File No: R/2020/6/B  
Our Ref: 2021/187303

**Response to RtS – Waterloo OSD Southern Precinct – SSD 10437**

Thank you for your correspondence dated 4 November 2020 seeking comment on the Response to Submissions (RtS) for the Waterloo OSD Southern Precinct. City staff have reviewed the information accompanying the RtS and provide our response at Attachment A.

Sheet title
General Arrangement Plan
Roof Plan

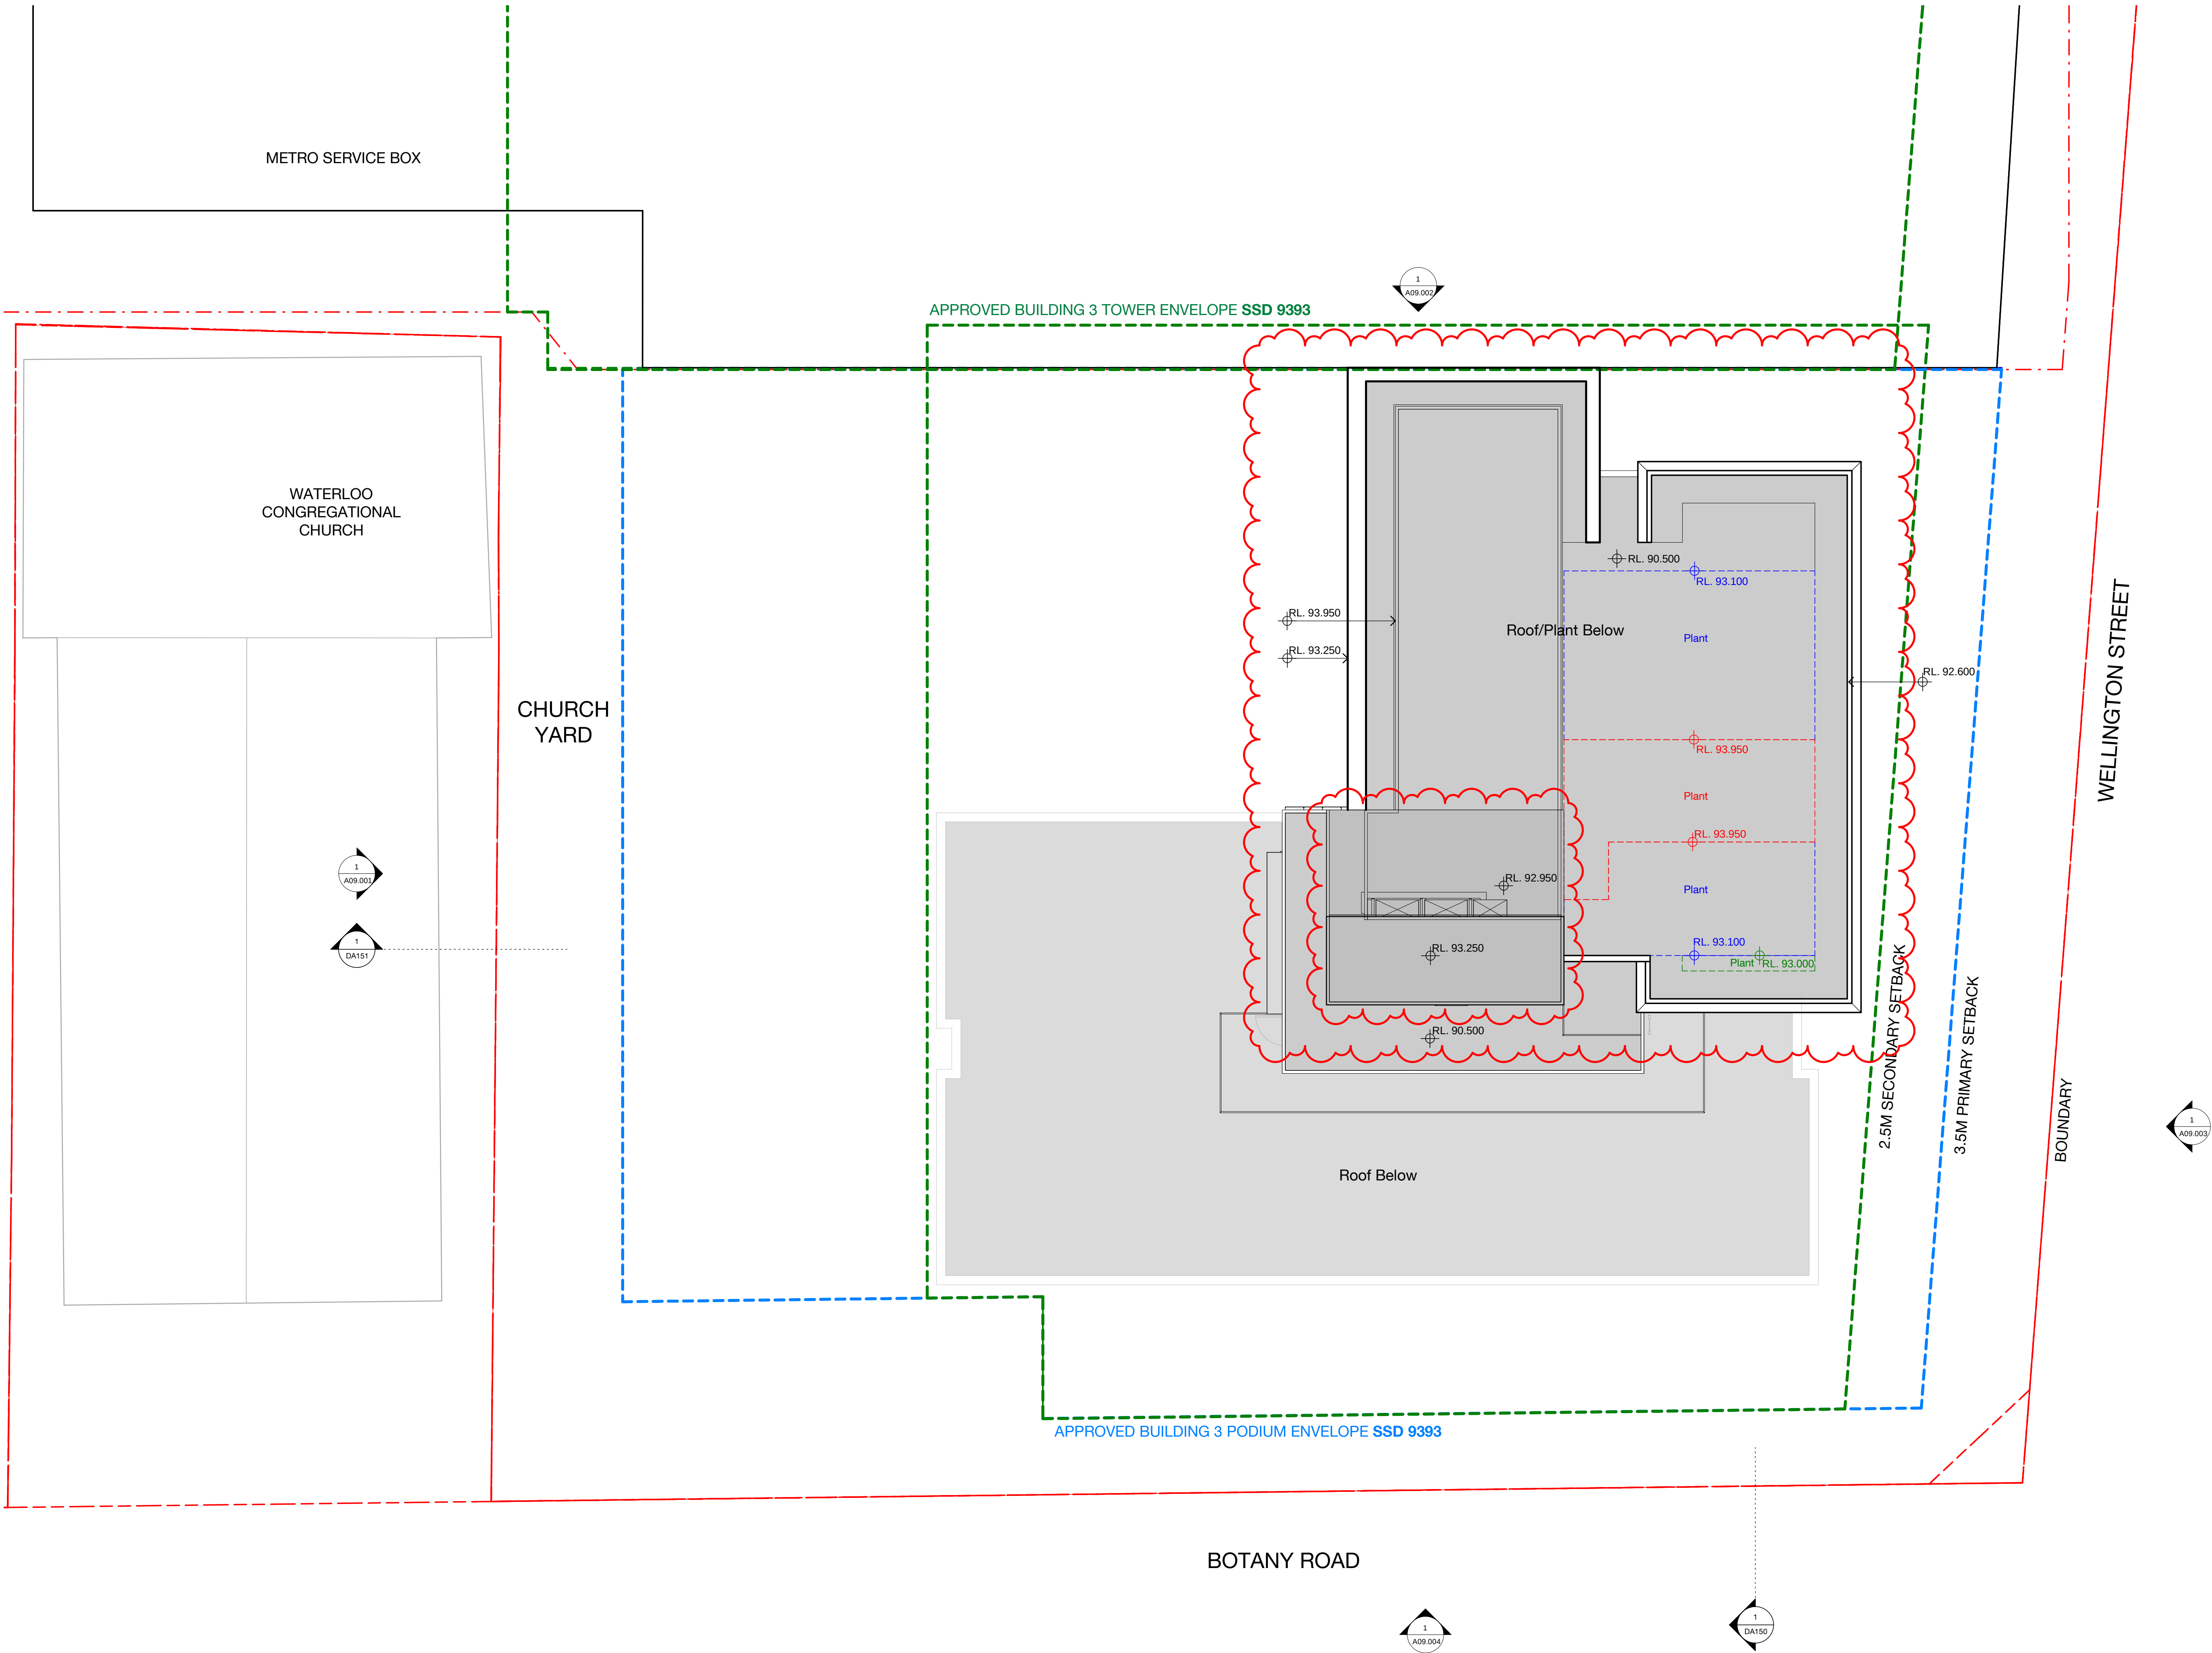
16. The height of the parapet on Building 3 identified in the image below should be extended from RL 87.35 to RL 88.9 to conceal views of the solar panels from the surrounding area whilst allowing for unobstructed solar access. All other parapets should be raised to a minimum 1.5 metres above the corresponding finished roof level, subject to mitigating any overshadowing impacts on Alexandria Park.

Status
AFT D&C Builder
Sheet number
WMQ-BLD3-BSA-AR-DRG-DA140
Revision
K

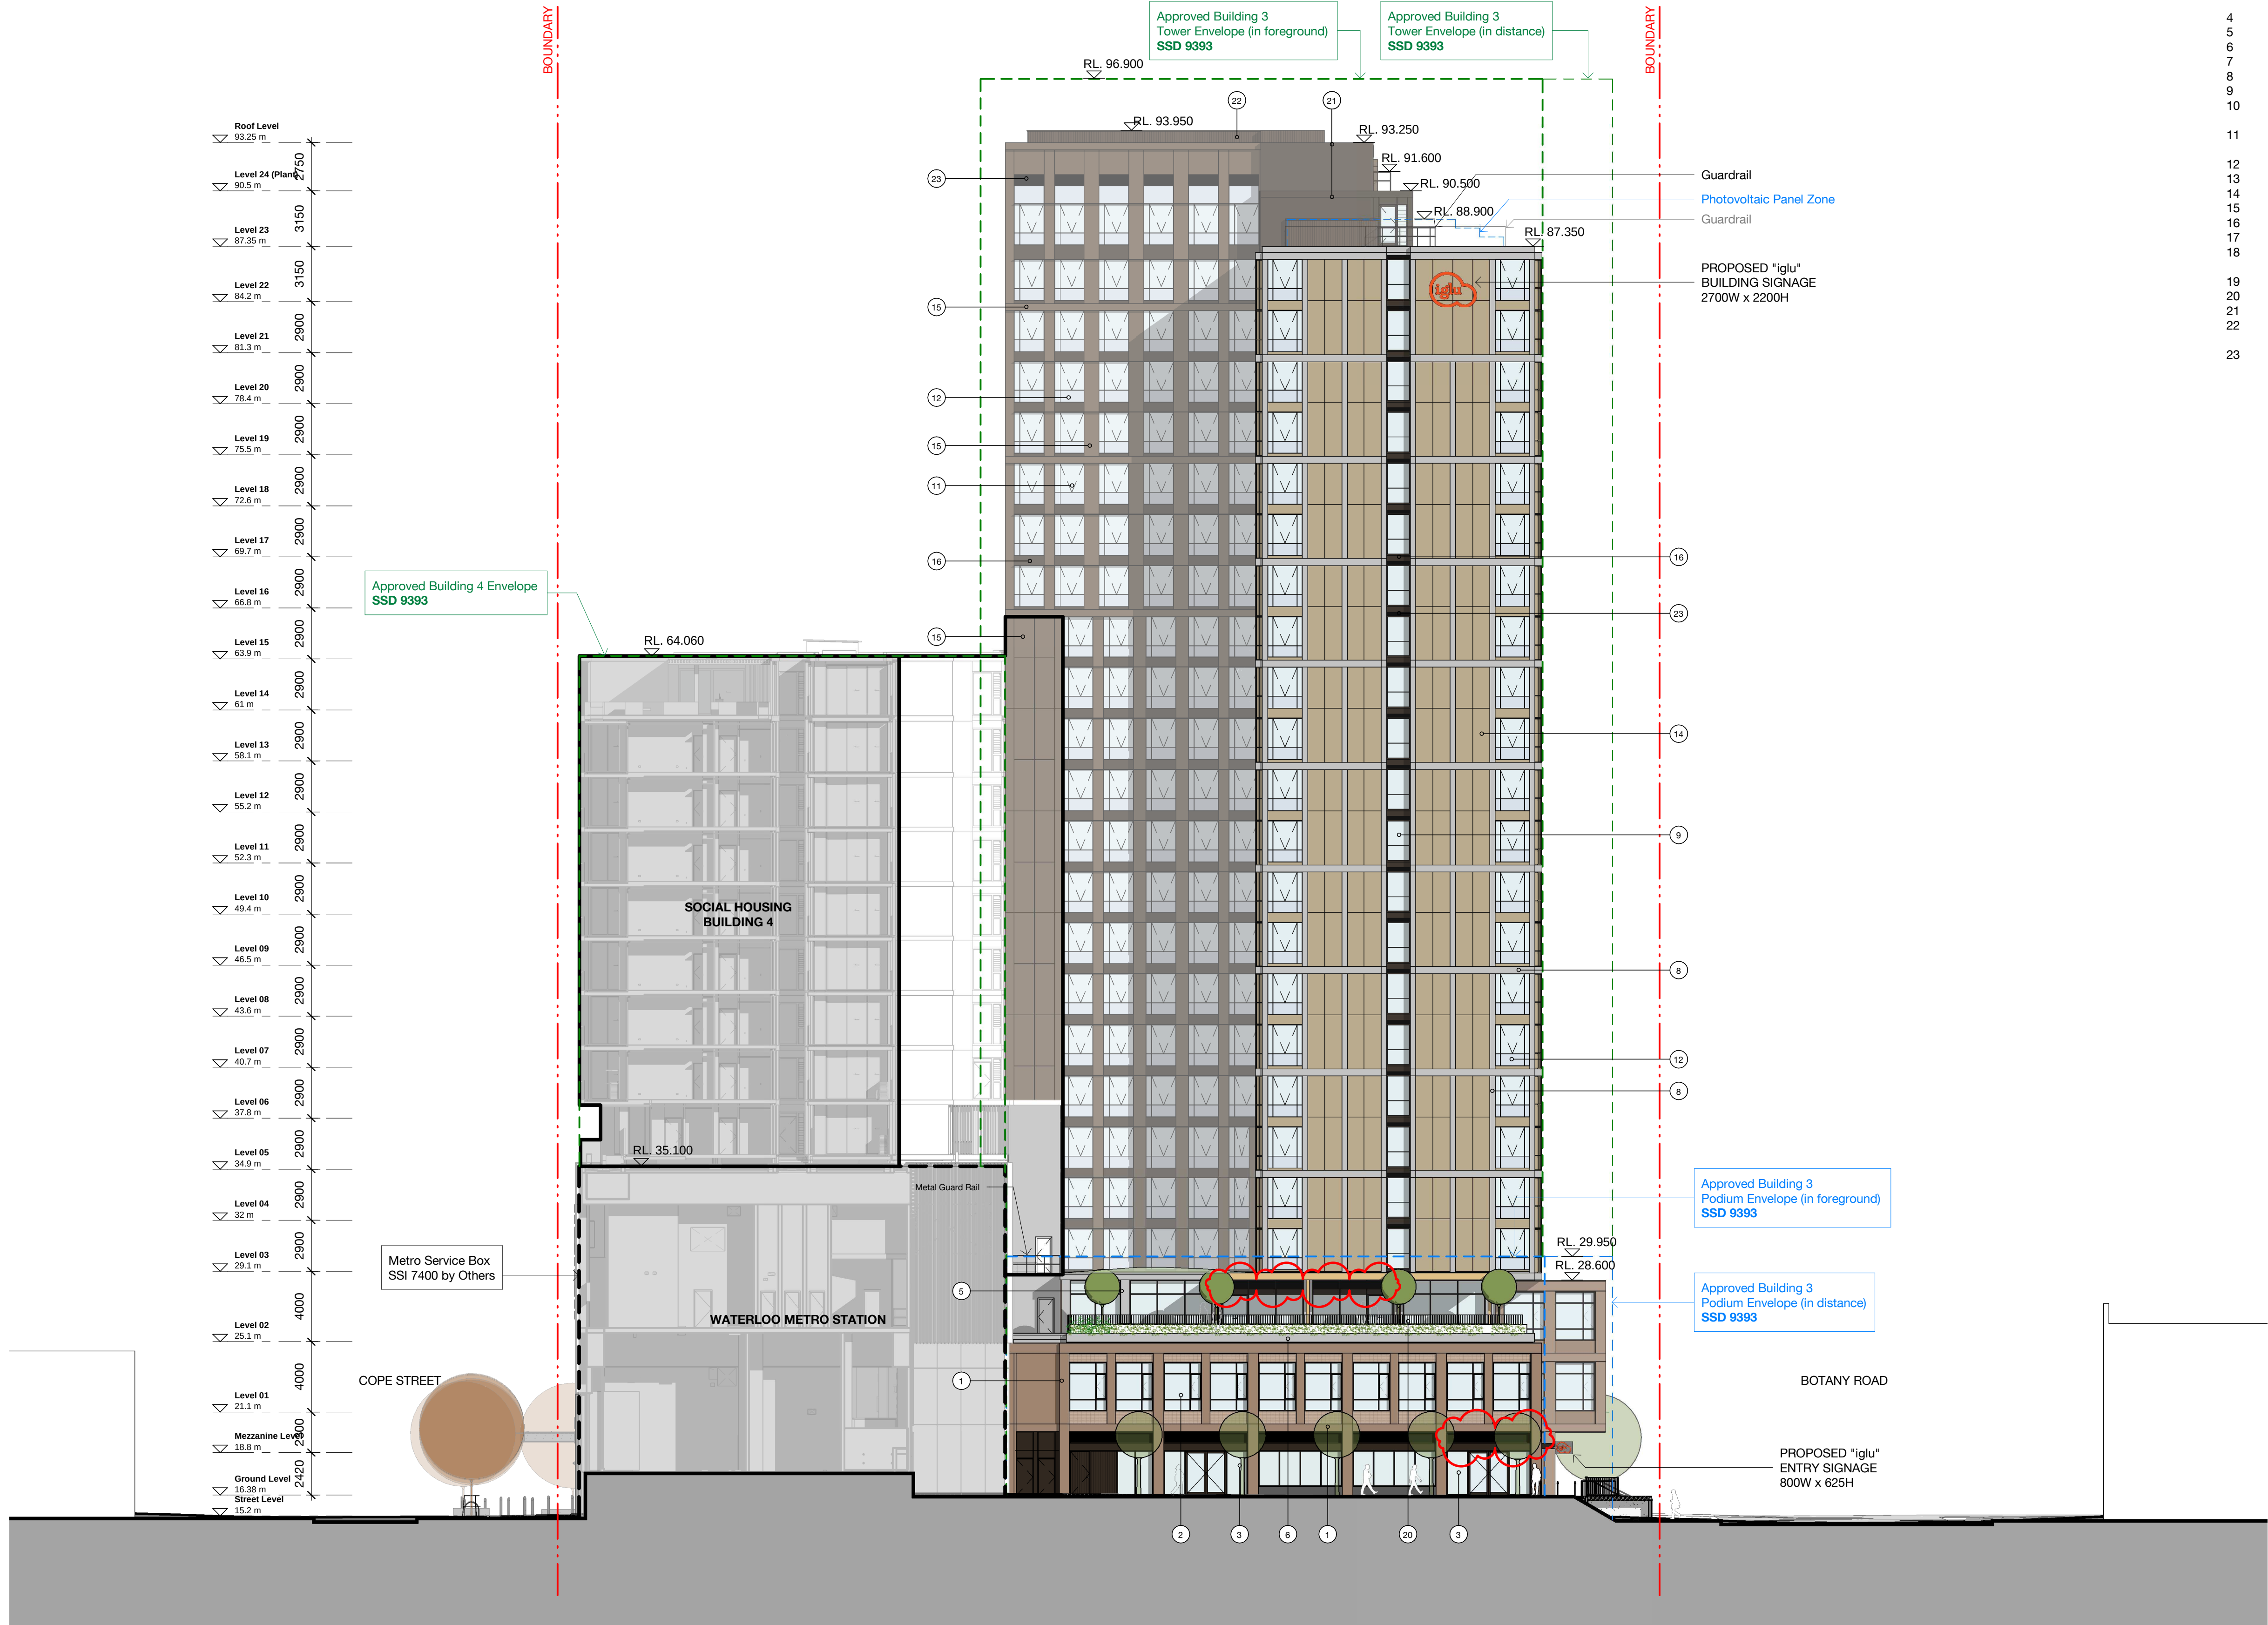
15. The additional glazing is acceptable, however, there is no variation in the colour of the grid and infill panels of the north or east walls. This monotony could be better treated with some variety in colour. A condition to this effect is recommended.

21. Cundall at Appendix P of the RtS have assessed the impacts of summer sun on the western facade of Building 3 using three treatment options. The results of the test are spurious at best, failing to consider the superior option of externally mounted, operable screens. Similar screens have been provided at Central Park, Barangaroo and 188 Day Street, Haymarket and are frequently used to successfully mitigate afternoon summer sun. The development instead is relying on only partial sun shading and tinted high performance glazing.
22. More generous horizontal shading above the lintels and vertical fins provided to the sides of windows should be provided to the northern elevation.
23. Views from the sun diagrams should be provided at the summer solstice from 8am to 5pm to demonstrate the efficacy or otherwise of the design to mitigate the heat gain from the summer sun.
